From: Nolan, Chris <Chris.Nolan@lancashire.gov.uk>
Sent: 13 October 2017 10:17
To: Stephen Kilmartin; planning
Cc: LHS Customer Service
Subject: D3.2017.0937 - Land at the entrance to Whalley Industrial Park Clitheroe Road Barrow

Planning Application No: 3/2017/0937

Proposal: One new dwelling and associated works.

Location: Land at the entrance to Whalley Industrial Park Clitheroe Road Barrow BB7 9AQ

Clitheroe Road, Barrow Visibility Splays

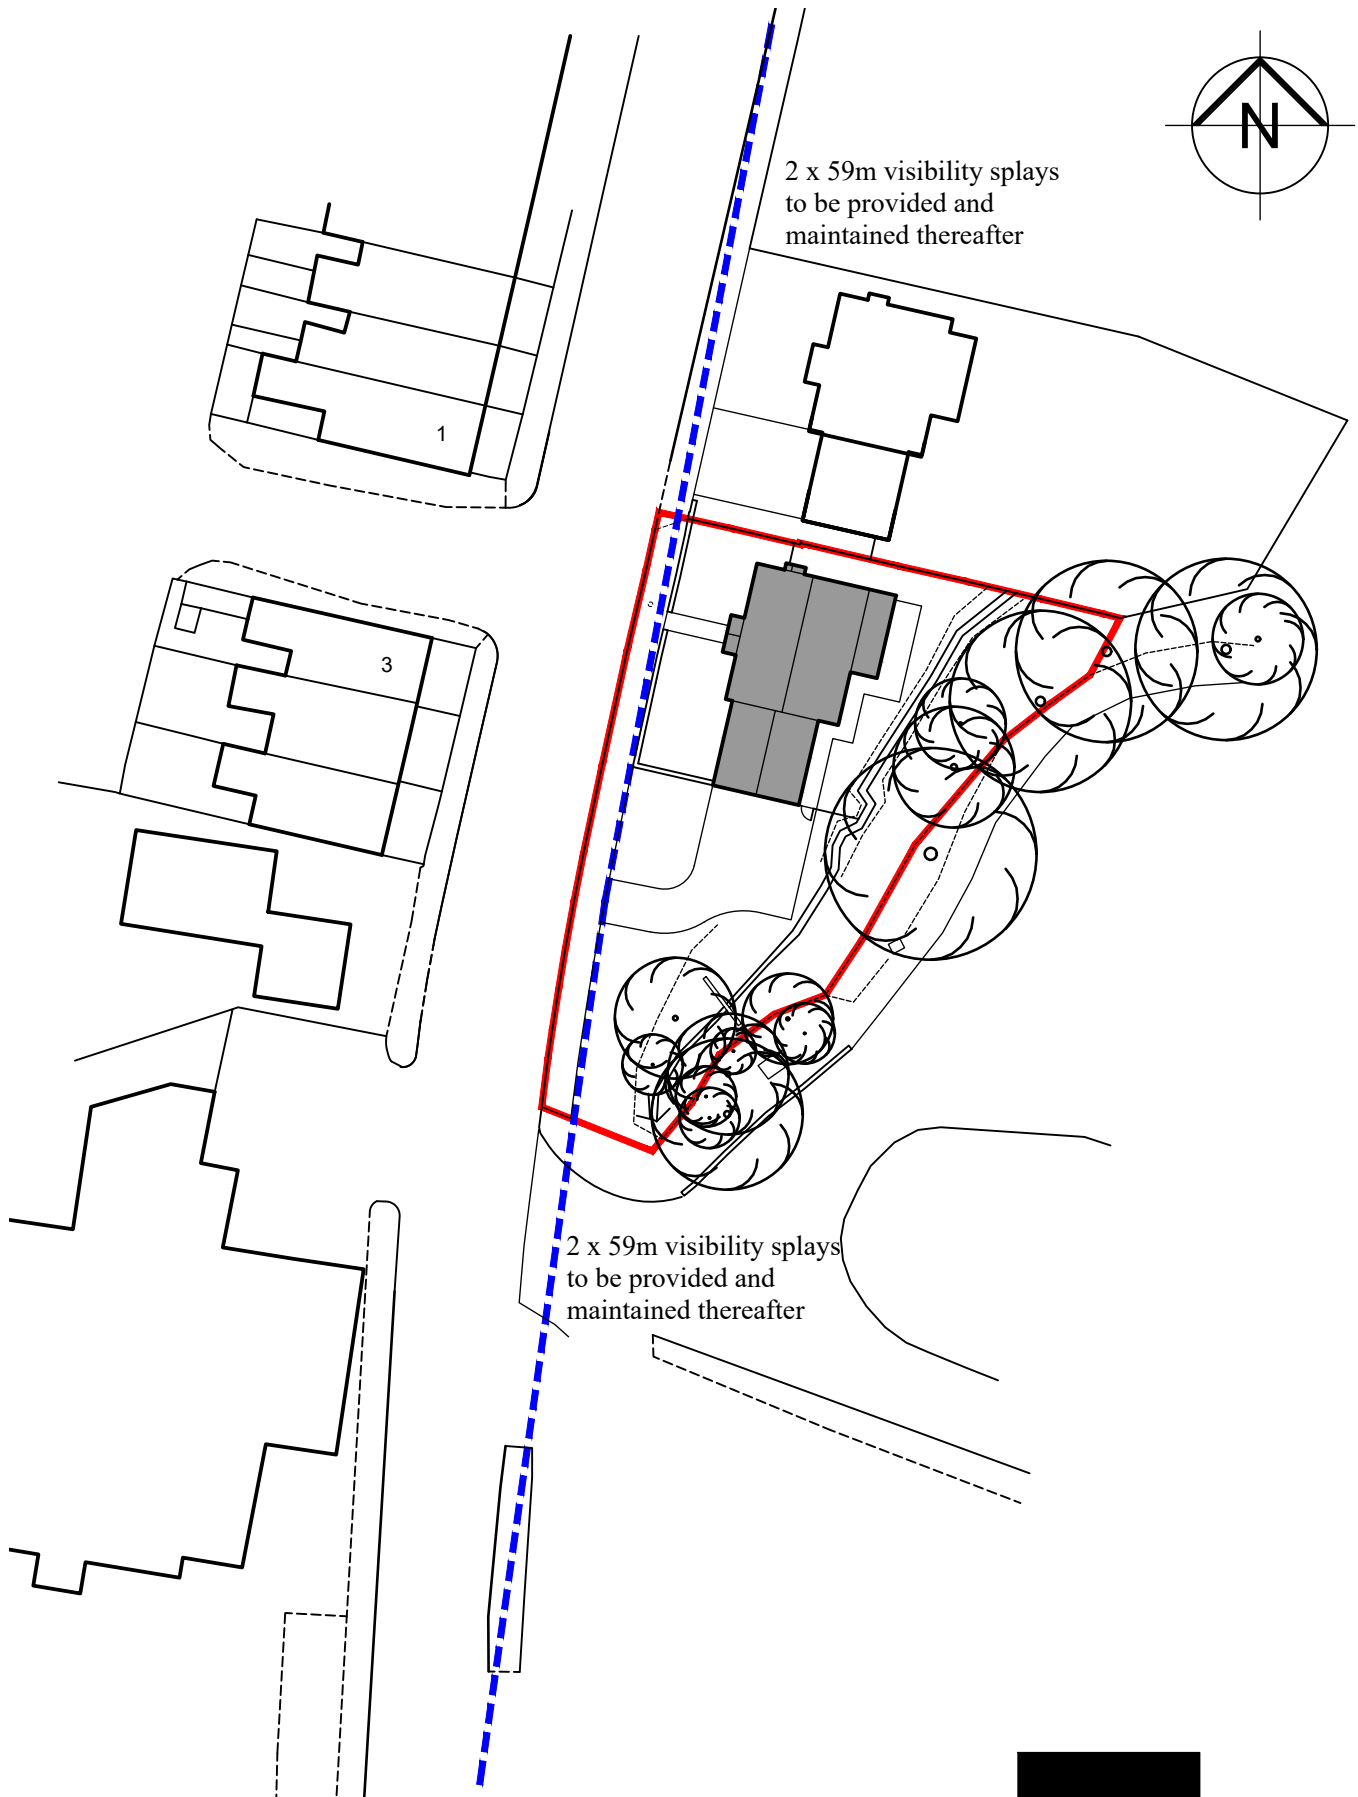
When I undertook my site visit it was noted that the proposal presently has good sight lines that would meet the requirements set out when the outline planning permission was granted. There could be some difficulties with the sightlines to the south of the site and for this reason I would like to see plans indicating the sight lines are achievable without crossing third party land. This concern was highlighted at the time of the outline application and the requirement at that time requested sight lines as follows:

"The sight lines of 2.0 x 59m to be provided in both directions from the centre of the drive onto Clitheroe Road. The site line requirement is based on table 7.1 from Manual for Streets and the traffic speed survey information / classified speed of the road / estimated wet road 85th percentile speed of 37mph."

Where acceptable sight lines at the junction are not provide I would raise an objection to the development in the interest of highway safety.

3. No part of the development shall be commenced until the visibility splays measuring 2.0 metres by 59 metres in both directions to be provided, measured along the centre line of the proposed new road from the continuation of the nearer edge of the existing carriageway of Clitheroe Road, to the satisfaction of the Local Planning Authority. The land within these splays shall be maintained thereafter, free from obstructions such as walls, fences, trees, hedges, shrubs, ground growth or other structures within the splays in excess of 1.0 metre in height above the height at the centre line of the adjacent carriageway. Reason: To ensure adequate visibility at the street junction or site access in the interest of highway safety in accordance with Quality of Development Policy and Transport Policy in the Local Plan.
